East Anglia ONE North and East Anglia TWO Offshore Windfarms

Applicants' Comments SASES Deadline 6 Submissions

Applicant: East Anglia TWO and East Anglia ONE North Limited
Document Reference: ExA.AS-8.D7.V1
SPR Reference: EA1N_EA2-DWF-ENV-REP-IBR-001340

Date: 4th March 2021
Revision: Version 1
Author: Royal HaskoningDHV

Plate 1: Threshold of hearing (BS ISO 226:2003)

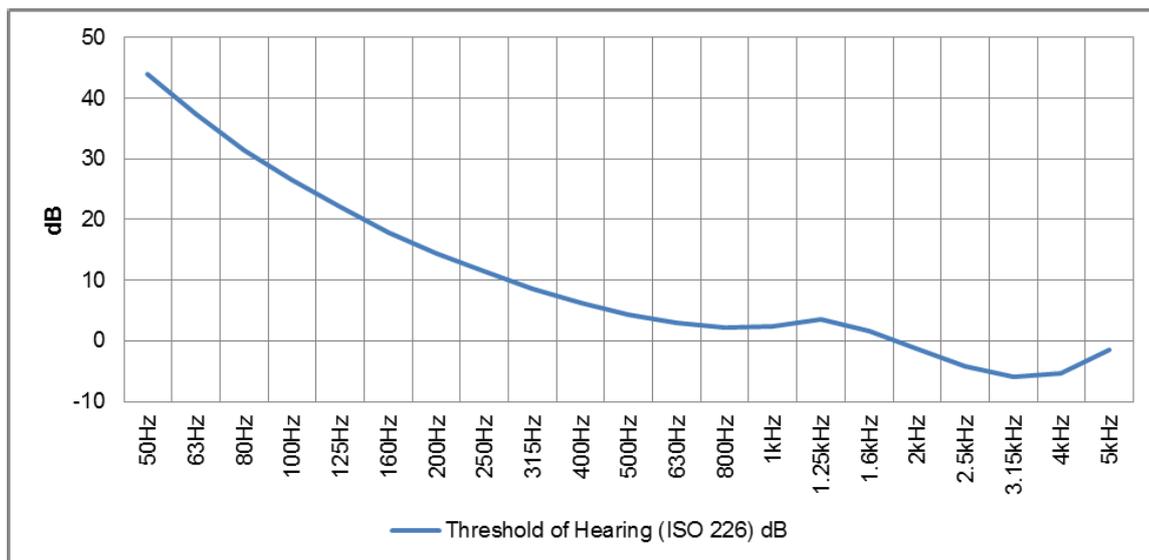
25	<p>The document contains an attempt to calculate the indoor sound level of tones at 100Hz and 200Hz (notwithstanding the fact that BS4142 requires the noise to be measured and assessed outdoors) and to assess the result against the threshold of audibility from ISO 226. They conclude that "it is considered that a 100 Hz tone in the specific sound from the substation that is no greater than 42 dB Leq,100Hz,outside is unlikely to be perceptible within any nearby dwelling and that a 200 Hz tone in the specific sound from the substation that is around 32 dB Leq,200Hz,outside is also unlikely to be perceptible within any nearby dwelling."</p>	<p>This method was discussed purely in order to provide additional context and relevant information for the Local Authority; it acted as an 'informative' addition to the main assessment relating to potential indoor noise levels.</p>

ID	SASES' Comment	Applicants' Comments
29	<p>From the NANR116 report the EA1 report takes the outside-inside correction as a minimum of 19 dB and says that "On this basis, the spectral level of a 100 Hz tone in the specific sound from the substation that is no greater than 42 dB Leq,100Hz, outside may be approximately 19 to 25 dB Leq,100Hz,inside". The report then compares this with the threshold of hearing from ISO 226 which it takes as 26 dB at 100Hz (for 50% of the population¹). Thus, on this basis, 42 dB (without A-weighting) outside gives 42-19=23 dB inside, 3dB below the 50% audibility threshold.</p>	<p>Notwithstanding that these comments relate to information reported to provide context to the assessment (and not to provide, in any way, the main assessment) for EA1, it is noted that the entirety of the argument put forward rests on SASES' consultant assuming a situation which is physically impossible with the equipment and plant to be installed at the substation.</p> <p>The substation will not emit the entirety of its spectral content as a pure tone of 100Hz and to suggest that it will be somewhat egregious.</p> <p>The 6dB tonal penalty would not apply because, as noted above, the situation SASES' consultant describes is physically impossible.</p>

30	<p>If the DCO Requirements 26 and 27 limit is an A-weighted level of (as now proposed) 31 dBA, and if it should be tonal such that all the spectral content was at 100Hz, this is a physical sound level, after removing the A-weighting, of 50.1 dB. After taking the outside to inside reduction of 19 dB this gives an internal sound level of 31.1 dB for comparison against the audibility threshold of 26 dB. It will therefore be highly perceptible (over 5dB above the 50% audibility threshold).</p> <p>In that case, the 6dB tonal penalty would apply, and the requirement 26 and 27 limits would be breached.</p>	<p>See response at ID29.</p>
31	<p>The outside to inside reduction of 19dB is for a ventilation opening of 0.05m² . On a summer night much more than this would be required, reducing the 19dB and increasing the audibility further. For a wide open window the normal assumption is an outside-inside reduction of 10dB. For a room with one of more modes at 100Hz the true figure could be less than 10 dB. It is the impossibility of knowing the specific</p>	<p>Notwithstanding that these comments relate to information reported to provide context to the assessment (and not to provide, in any way, the main assessment) for EA1, the Applicants are fully aware of the reasons that BS4142 does not provide for the assessment of indoor sound levels and this is why the 'NANR116' detail is provided specifically and</p>
